**Re Planning Application No. AW/344/14/HH - 68 The Drive, Craigweil**

As owners of the neighbouring house we wish to register our objections to the above plans as follows:

ROOF PLAN

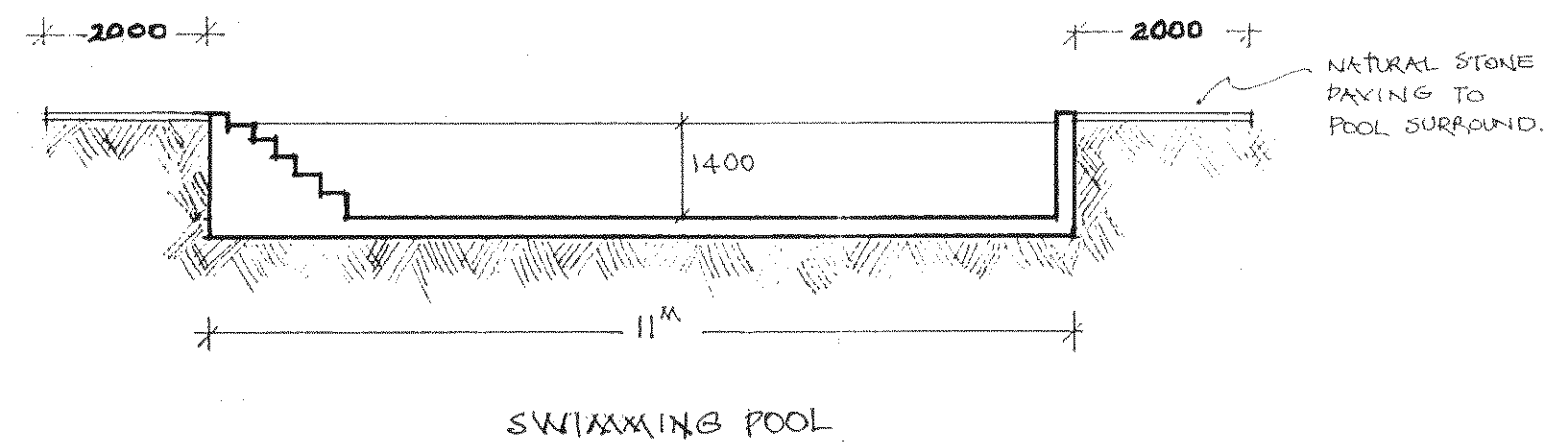
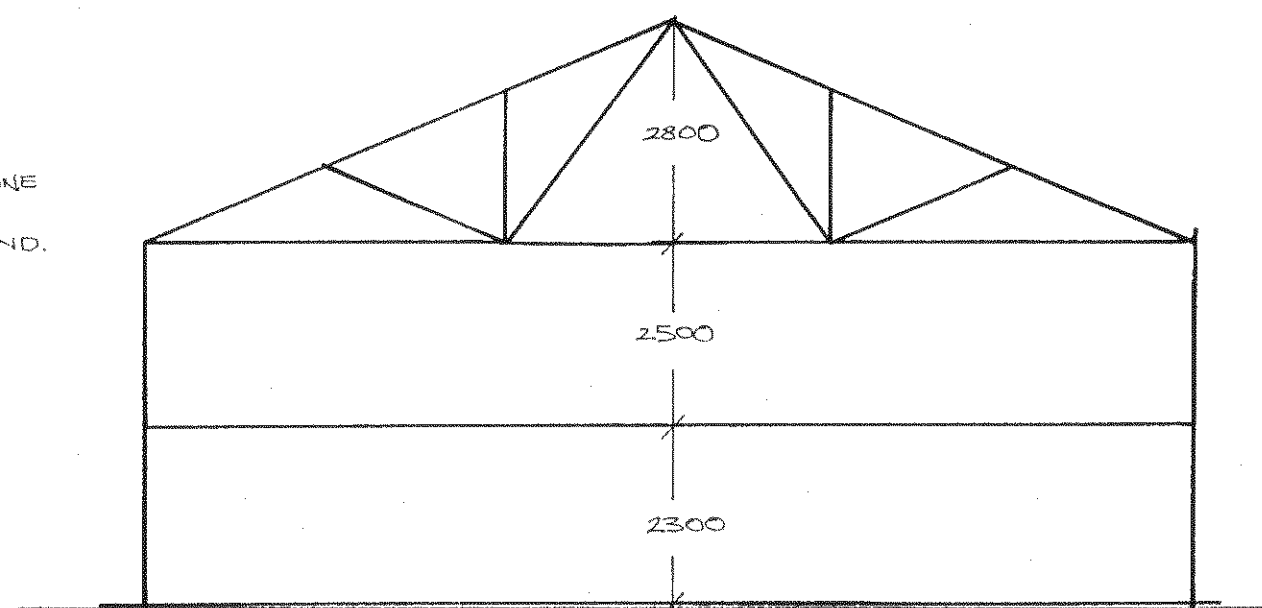
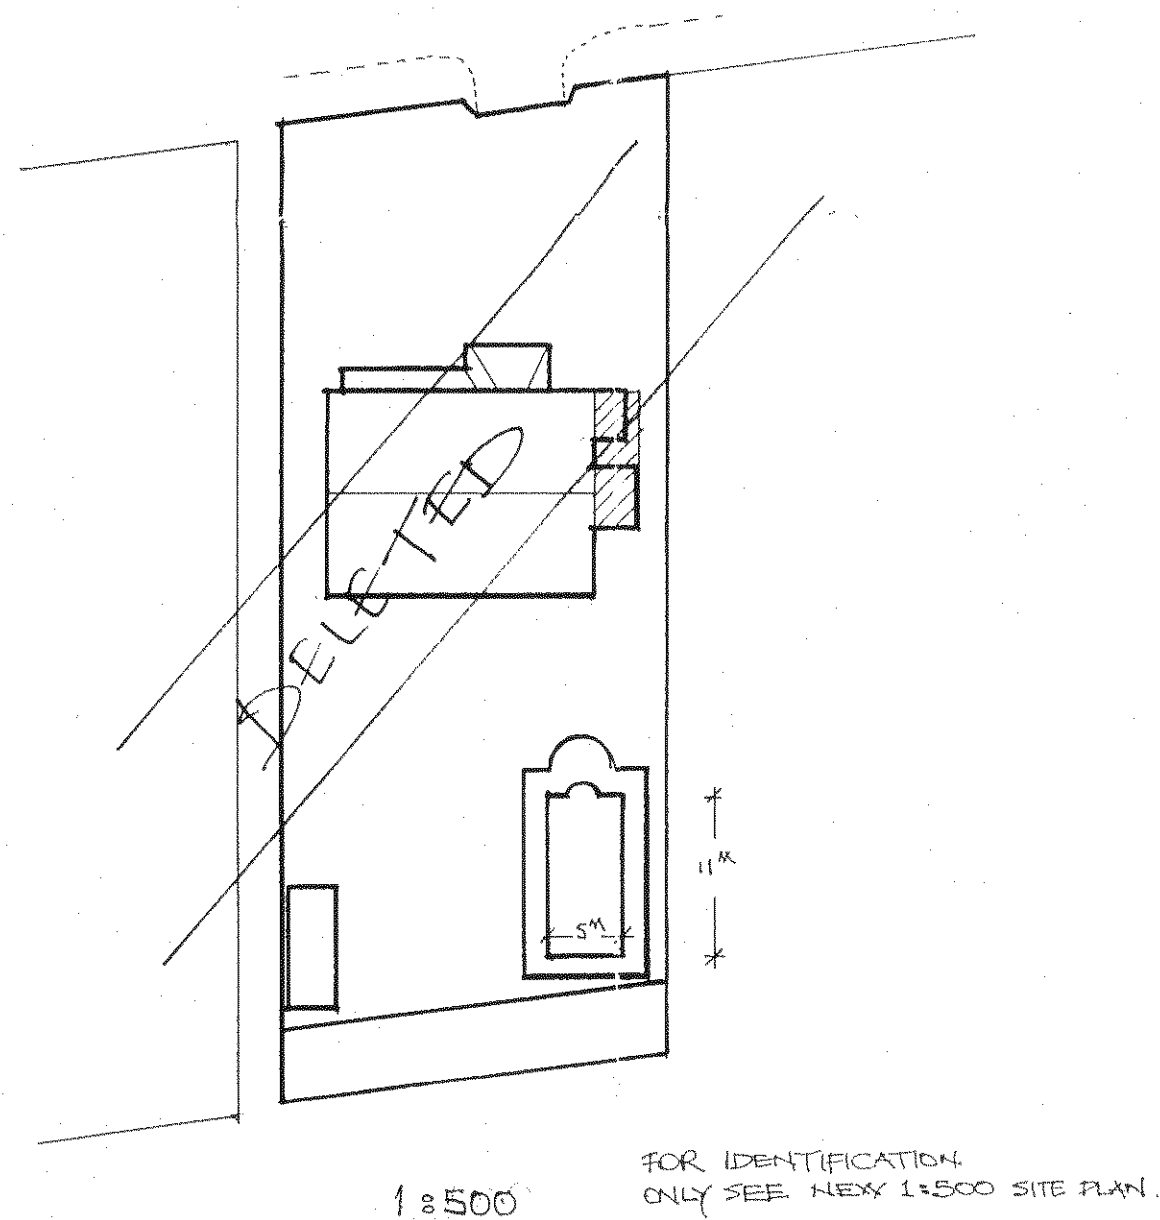
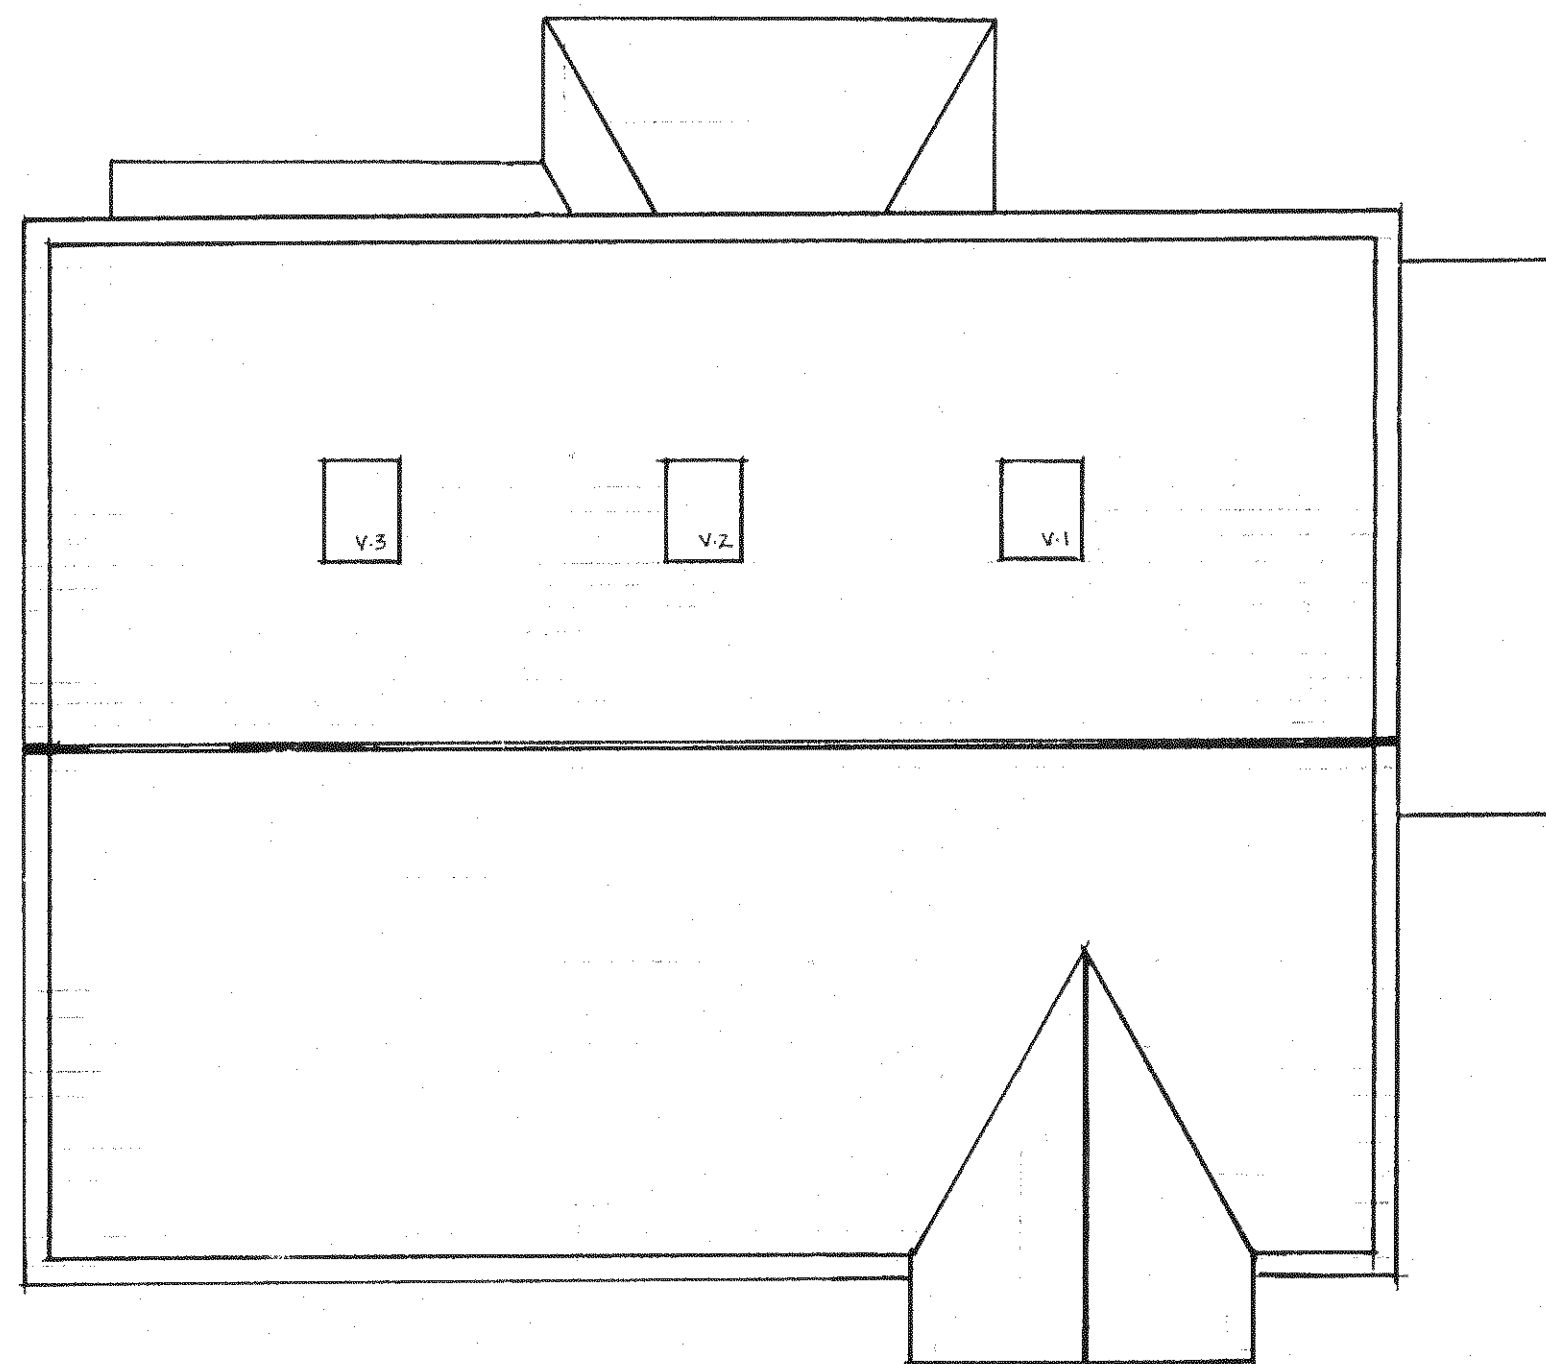
**2. Gable Roof to existing first floor living room extension**

No. 68 was built such that much of the house lies beyond the rear elevation of our property. The proposed gable will increase the spread of the roof height reducing the amount of mid/late afternoon sunlight that we currently enjoy in the garden as the sun moves westward in the sky. The proposal of a gabled roof can only be for cosmetic reasons; the house has existed without problem all these years with a flat roof over the first floor living room extension. The gabled roof is not a necessity and would disadvantage us in terms of being able to enjoy afternoon sun in our garden.

68/2014/30P

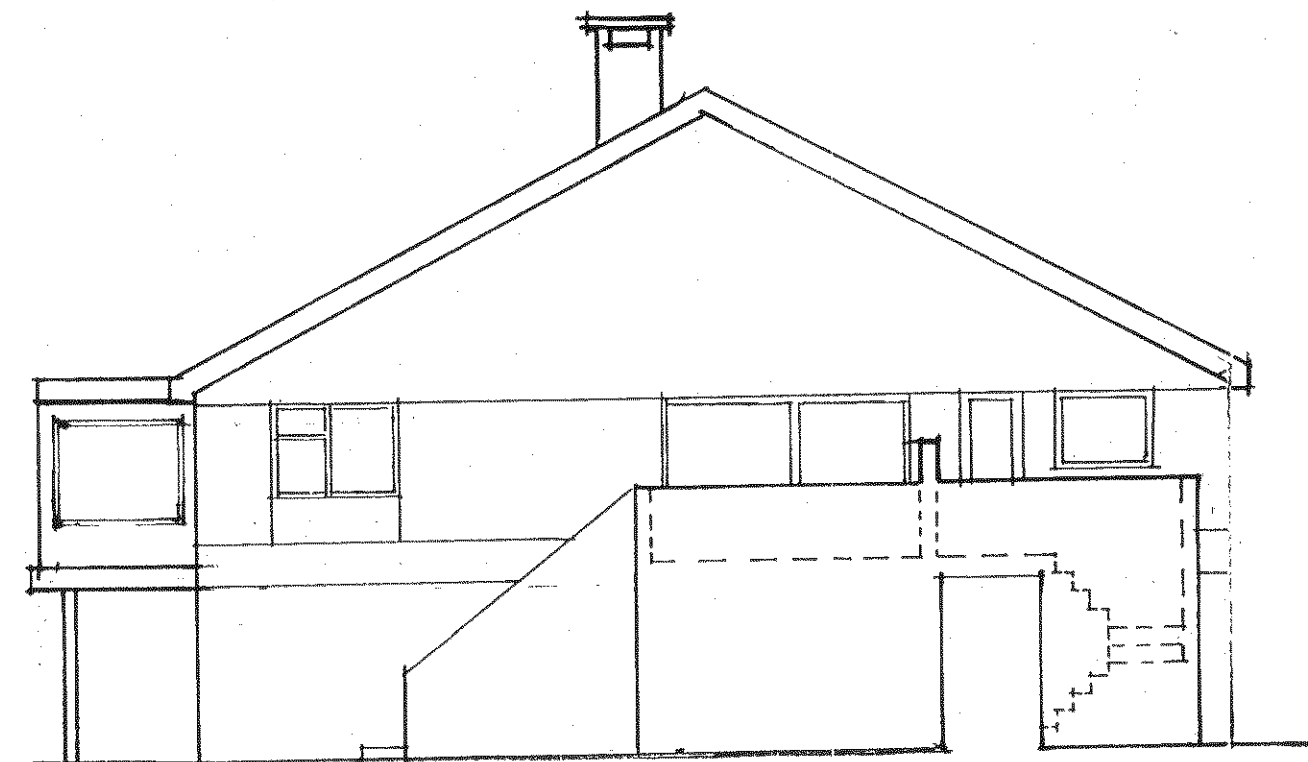
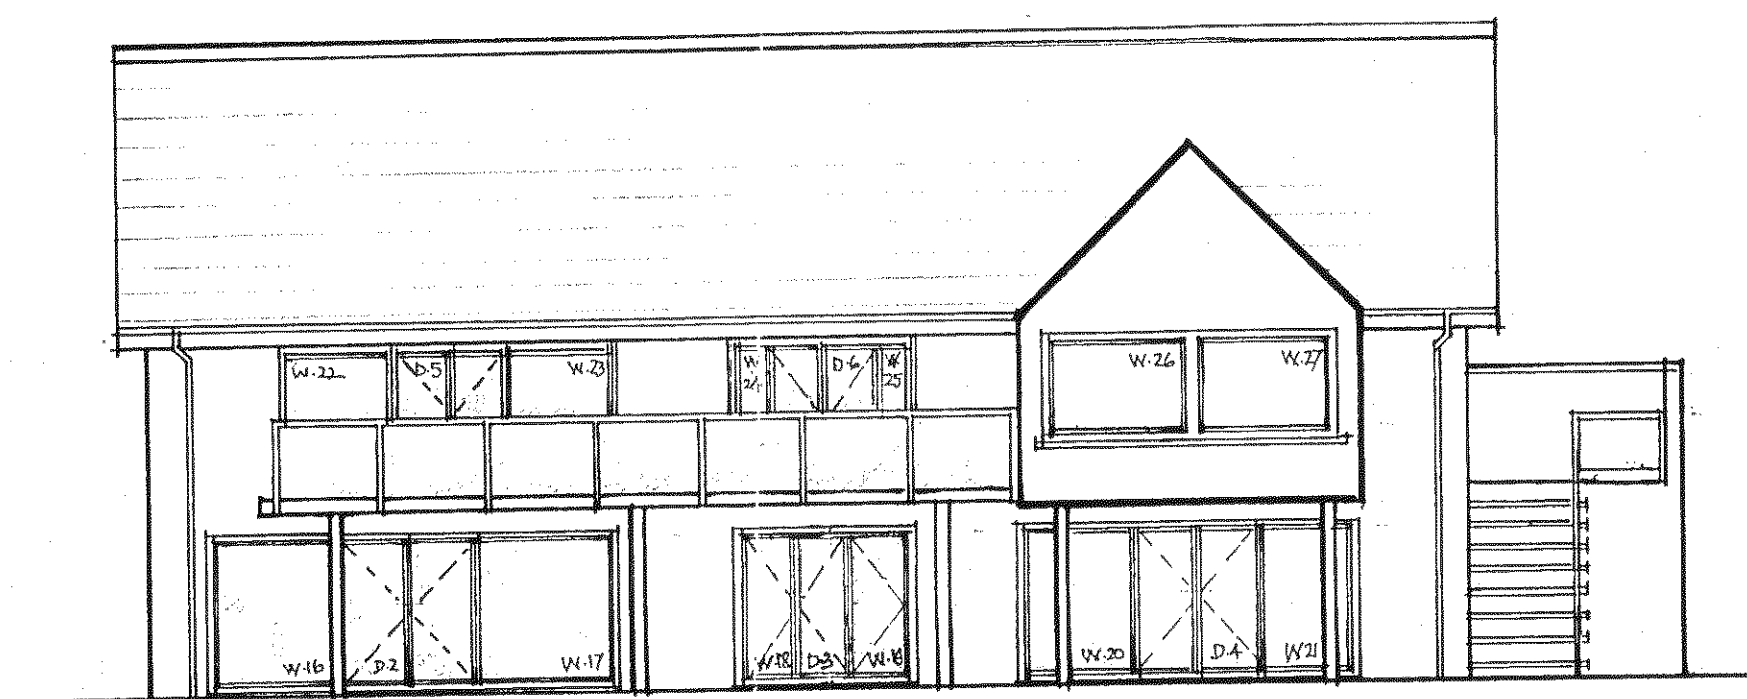
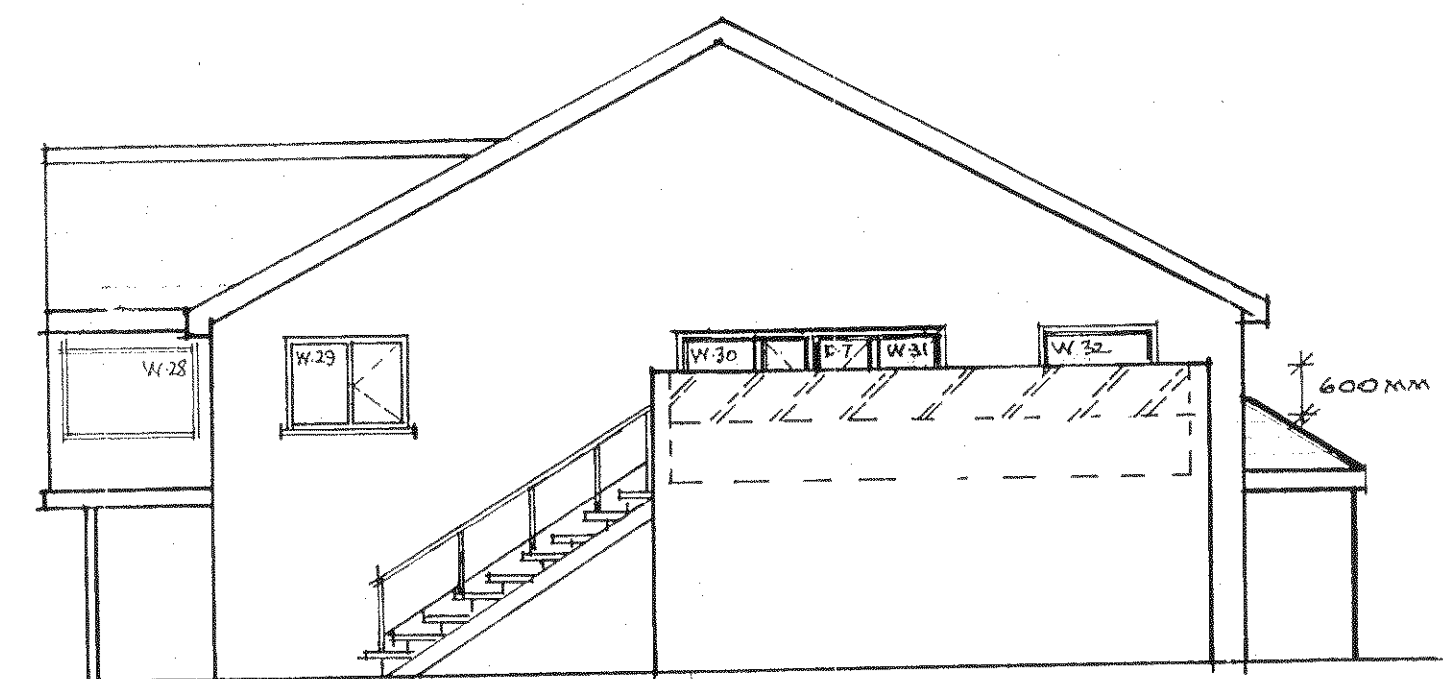
**1. New external steps at rear of side extension and associated "Terrace" as indicated on Document 68/2014/30P Rev. B and Document 68/2014/60P Rev. A**

The house is an "upside down" house and the existing arrangement has a main staircase on the outside of the rear elevation from the first floor to the garden, plus secondary outside stairs on the eastern elevation to ground level. The stairs on the eastern elevation are close to the boundary with our house and overlook our bedroom.

The plans provide for the main external staircase at the rear to be dispensed with, thus making the stairs on the eastern elevation the only external access from the first floor. It is reasonable to assume therefore that this would generate a doubling of traffic on those steps from which we have already experienced significant noise intrusion with loud phone conversations being conducted on the staircase. The plans seem to provide for what is termed a "terrace" on the first floor eastern elevation. The proposed terrace is both wider and longer than the current access to the steps and seems to us to have been designed to accommodate a degree of external living. It would appear to have potential for the noise level to increase and for even greater intrusion into our privacy. It is certainly a change of use from the existing arrangement.

We must question whether any external access from the first floor to the ground floor is an essential. If, for safety reasons and not just reasons of convenience, the answer is that it is essential, we would suggest that the stairs be retained on the middle of the rear elevation where they are currently and where they cause the least invasion of privacy to any neighbours. There would be no need for additional stairs on the eastern wall in that case.
